Article 21 of the Town and Country Planning (General Development Procedure) Order 1995
Application for approval of details reserved by condition 4 of planning application LU/175/08
Travis Perkins Site Pier Road, Littlehampton,

Condition Number 4

DRAWING NO.
07161 - L01.03

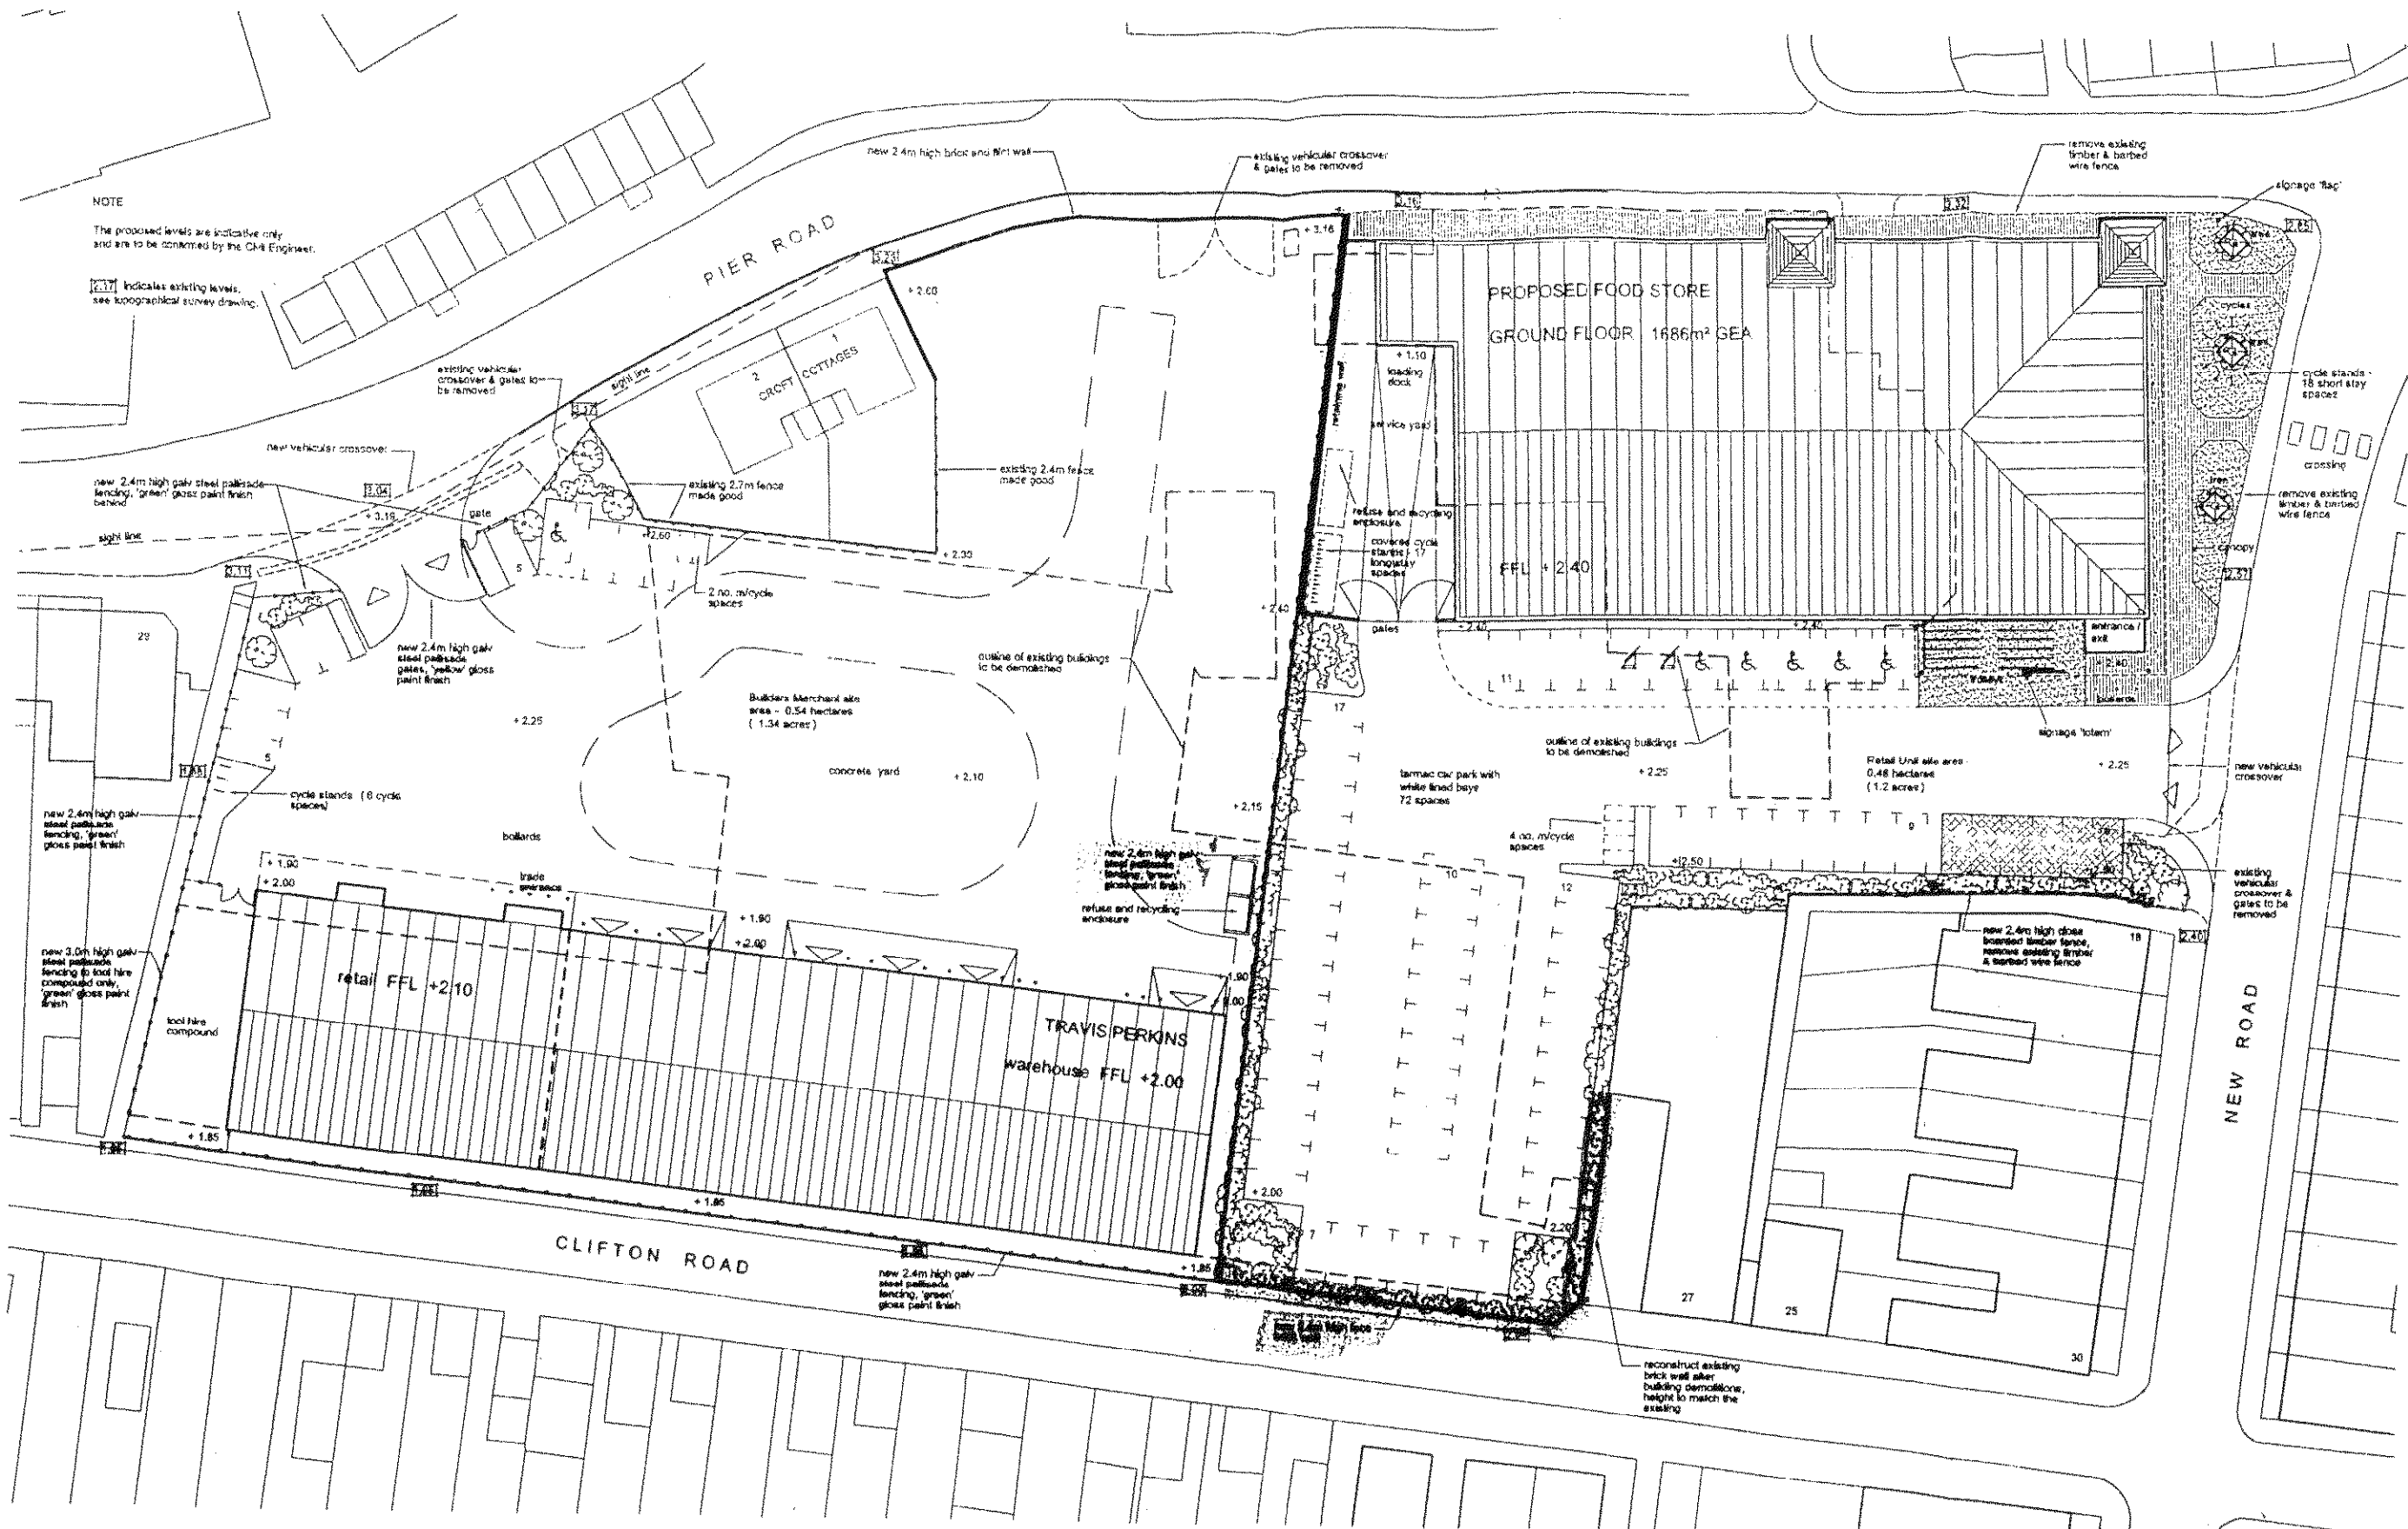
Arun District Council have decided to **APPROVE IN PART details reserved by condition** With the exception of the proposed 2.4 m high wall adjacent to Clifton Road, this condition is discharged, on the basis of the information contained in the agent's letter dated 17-12-2009 and on the attached plan drawing no. 07161-LO1.03 rev.B relating to the retail unit only. The section of 2.4 m high walling adjacent to the footpath in Clifton Road requires structural design and details of masonry walls including expansion joints to be submitted for approval before this element of the proposed boundary treatment can be agreed.
